From: Thomas Callaway
Sent: 08 April 2015 13:58
To: Planning.Responses
Subject: RE: Planning Consultation on: BR/329/14/PL

APPLICATION **BR/329/14/PL**

Site Address: Tesco Superstore Shripney Road Bognor Regis PO22 9ND

Description of Works: Extension to existing Dotcom facility with new adjacent secure compound consisting of 2.4m Paladin type fence and steel gates to accomodate Dotcom overnight van parking plus minor changes to the car park layout.

PROPOSED DOTCOM PLAN

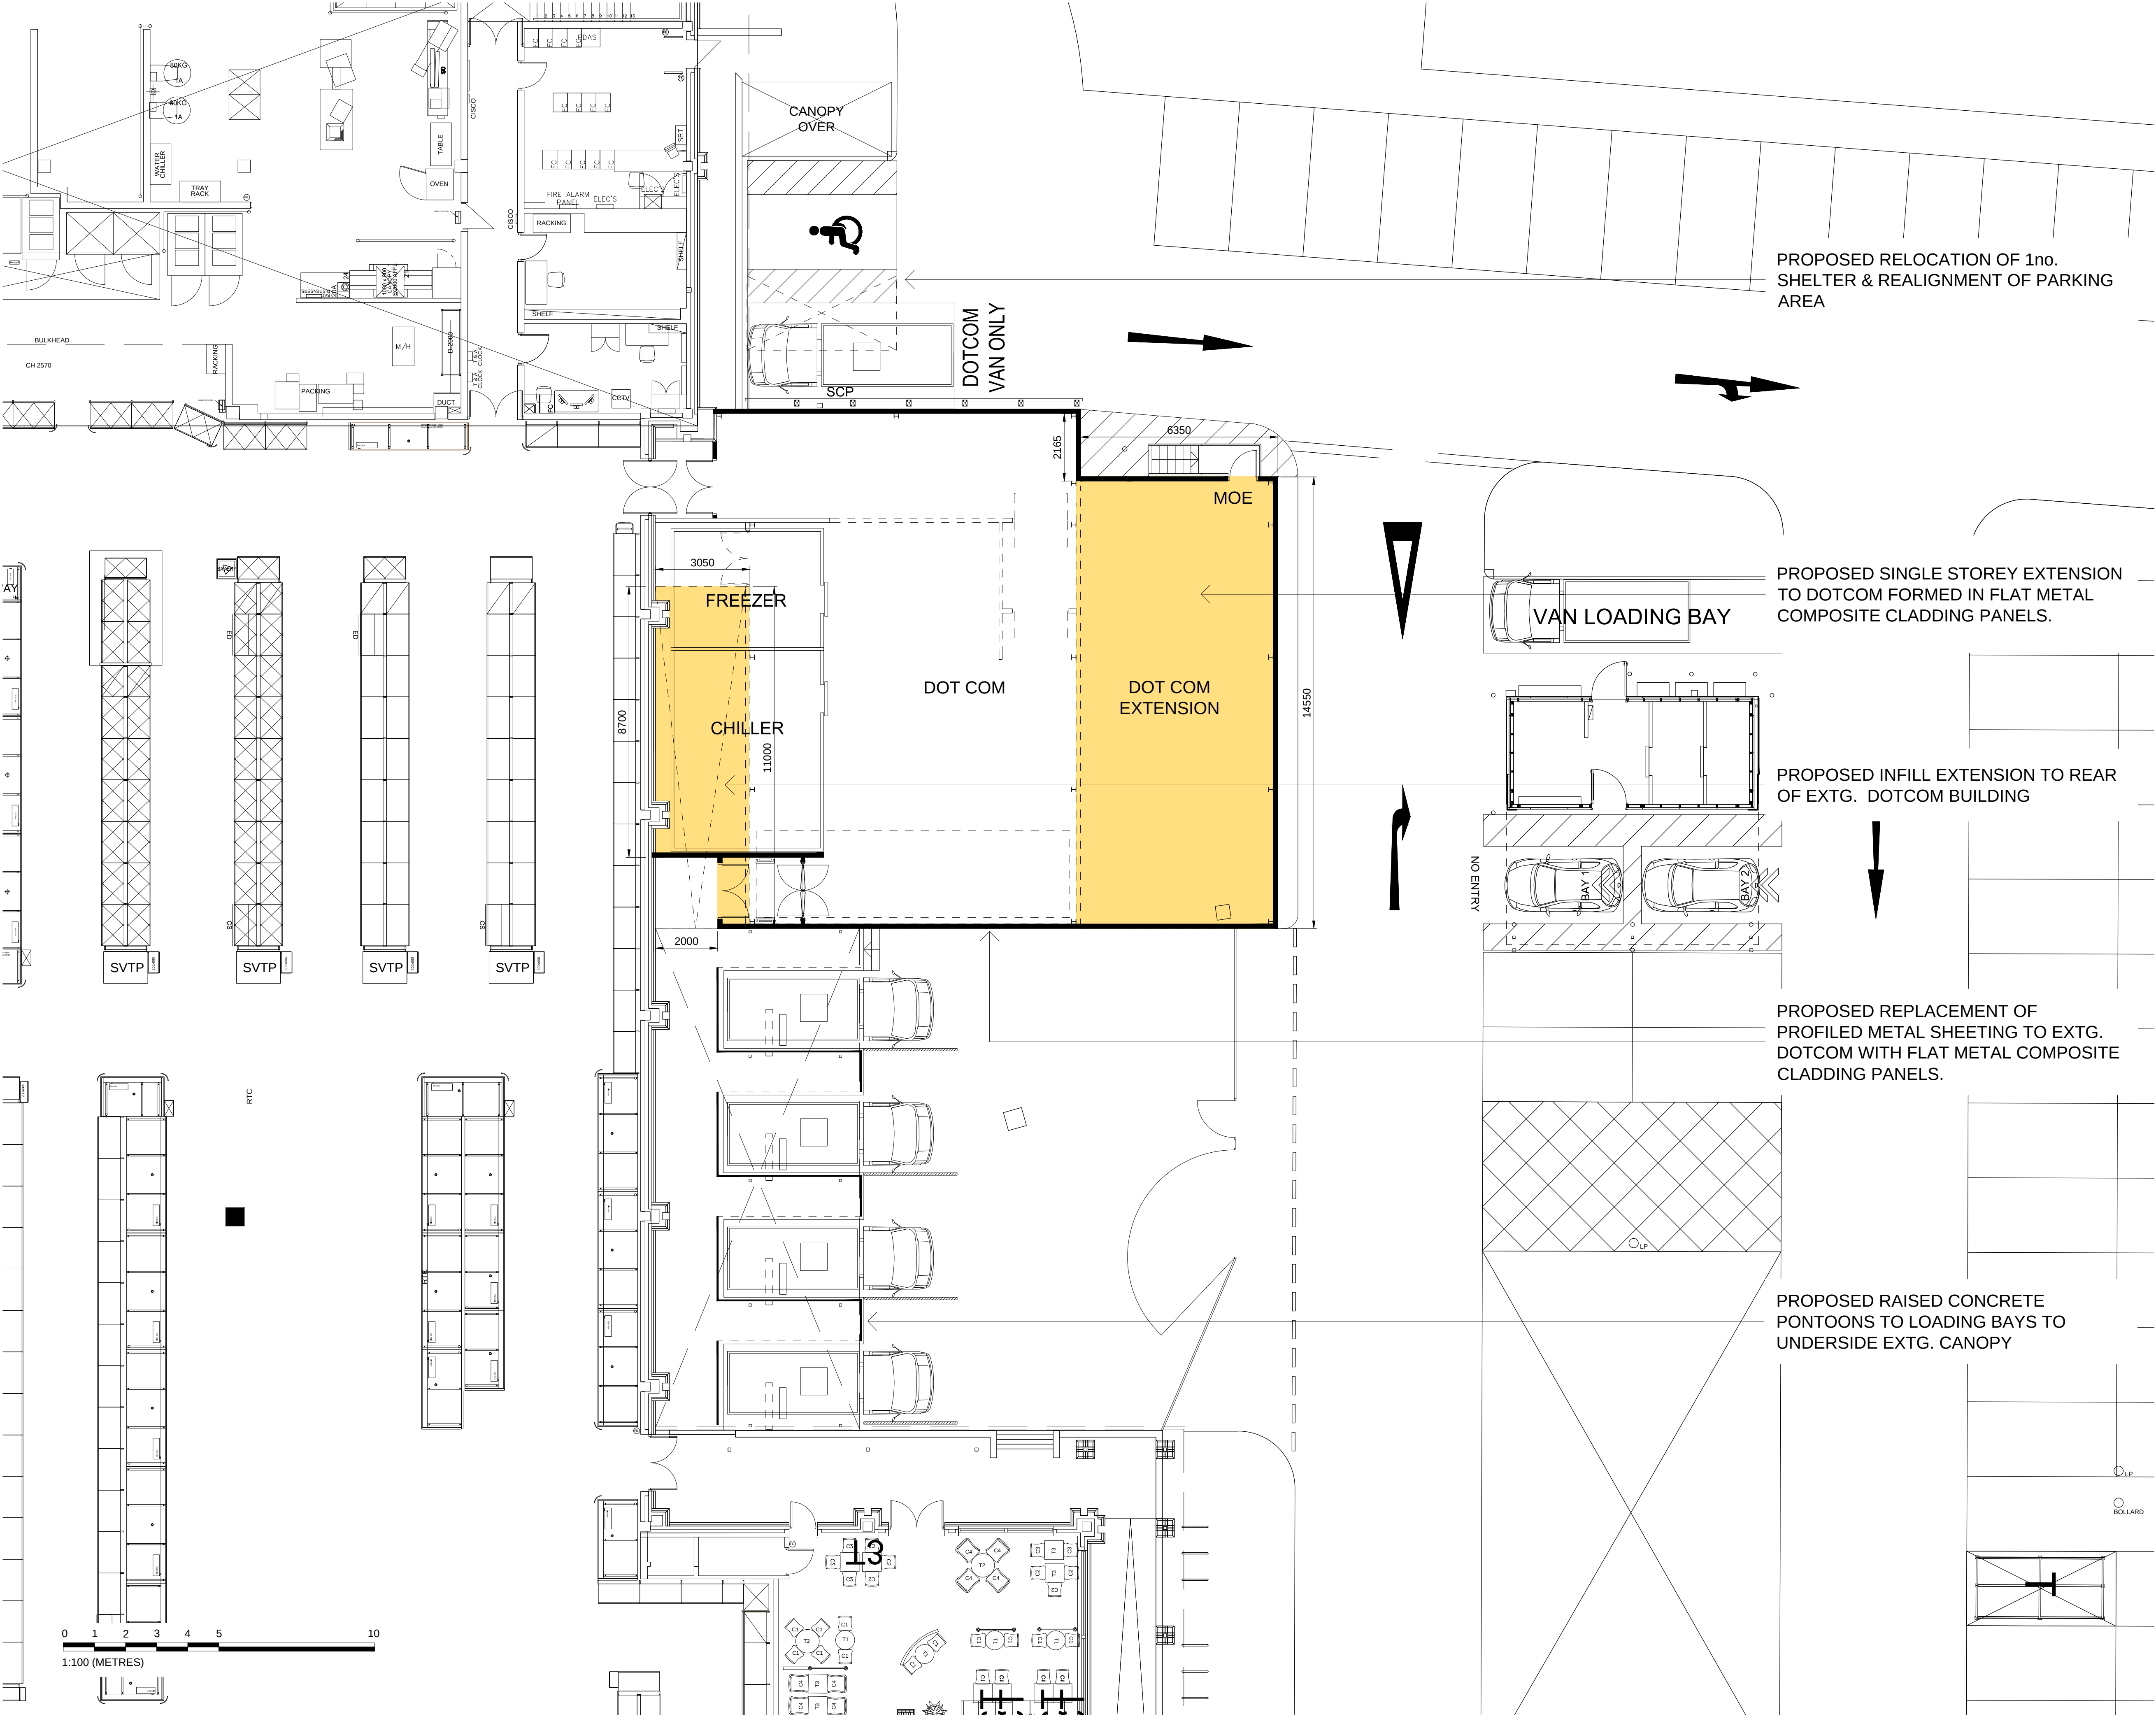
The EA should be consulted to ensure that the proposed extension does not fall within the designated flood storage area in the car park. As the proposal extends onto hardstanding, the existing drainage should be suitable for the proposed extension.
